Scale: 1"=150'
PCD File No. AL2217

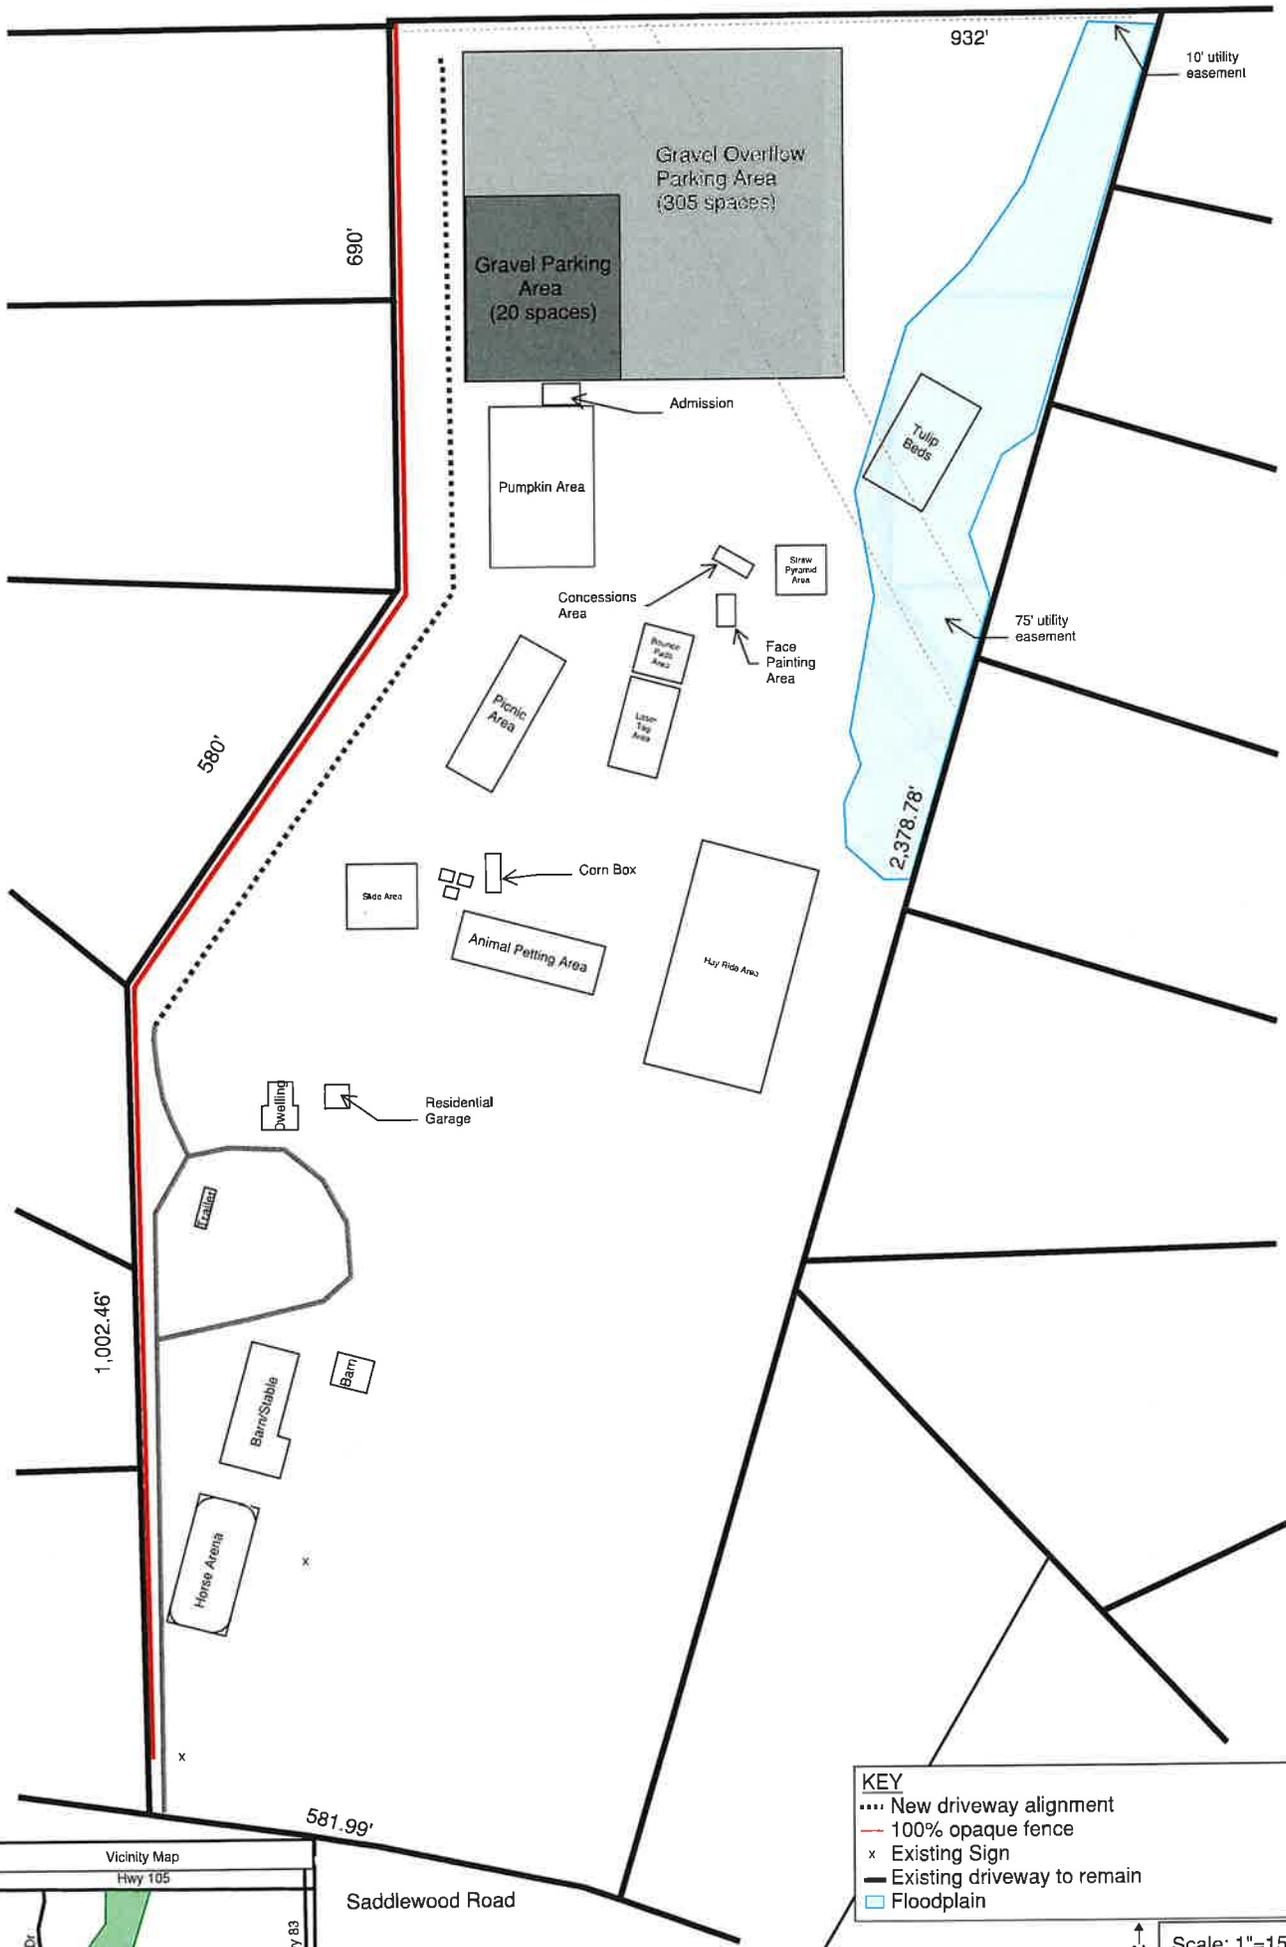
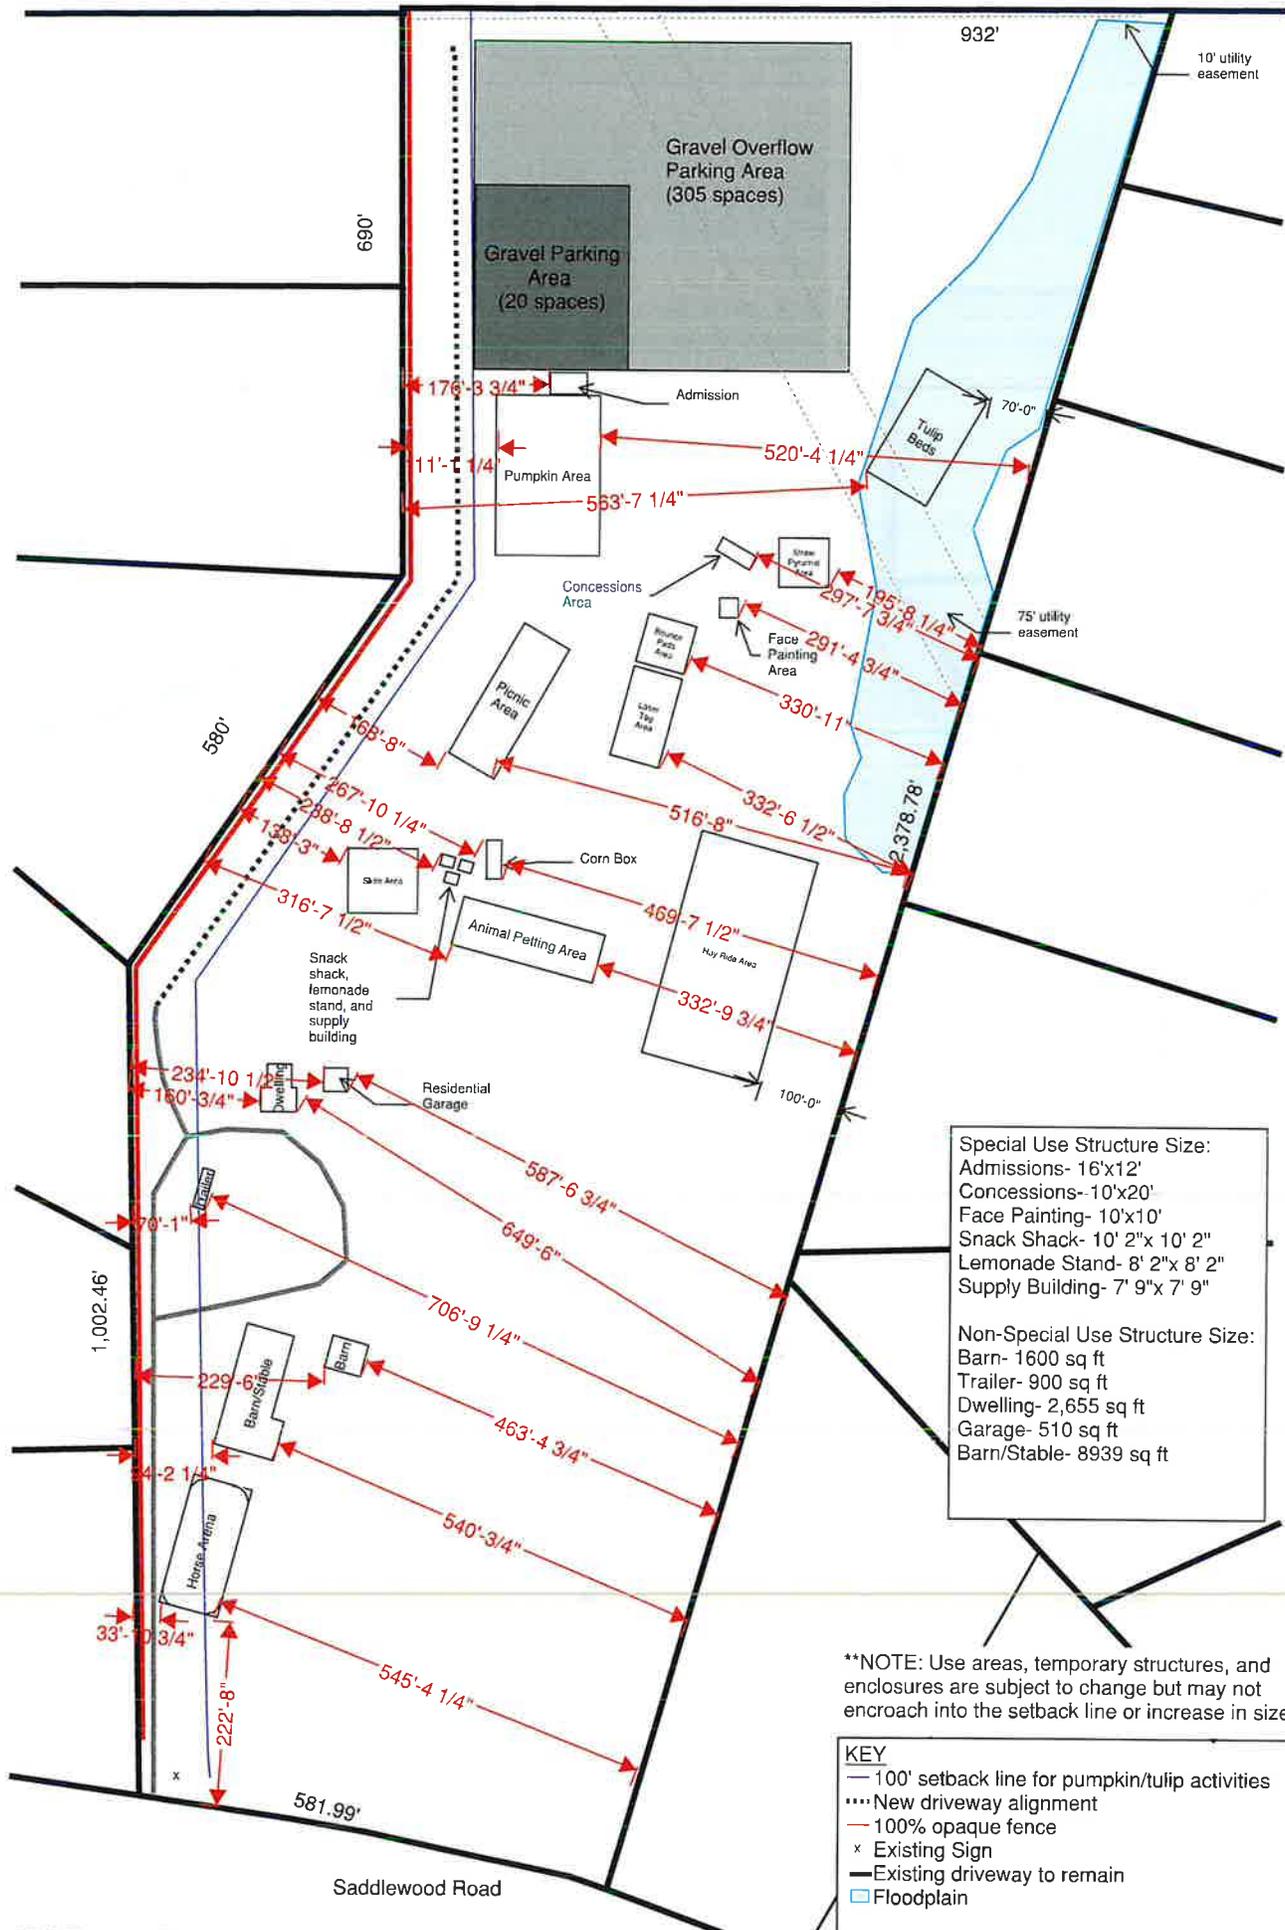
Based on the scale provided, the property boundary measurements appear inaccurate.

Please list the building square footages and depict the building setbacks from the property lines. It may be necessary to create a second page if you believe the page is too cluttered. Revised

Show the location of the existing signage. Revised

Layout of the parking area? How many parking spaces does this accommodate? Parking computation is required. How will the traffic circulate through the parking area? ADA parking/pathways/etc? There is no indication of accessibility for ADA on this plan.

Remove access from site plan since deviation was denied for temporary access.

One of the most important details associated with this request is the proposed number of guests and how they will circulate on the property. Please provide this level of detail at the special use stage. In rural areas, parking lots of more than 25 cars shall be paved. How will this be addressed? Dust from the unpaved components is already a noted concern on this property.

Will the overflow parking also be gravel or paved? Revised

What is this? Why is it only on the west side of the property? It is also not dimensioned on this plan.

What kind of fence? Please note that a chain link fence will not provide adequate screening. Revised

Per the comment review meeting, this detail will be provided at the PPR stage. Parking will be provided to allow for up to 325 vehicles.

The scale appears to have been altered when flattened. If this occurs again, the calibration tool will work. Either way, a note has been added to indicate a survey will be submitted at the PPR stage. Additionally, the items are all movable and may be relocated on the property provided they are not within the setbacks.

One of the neighbors identified that they desired a setback from the property line for all activities. this is to accommodate that request.
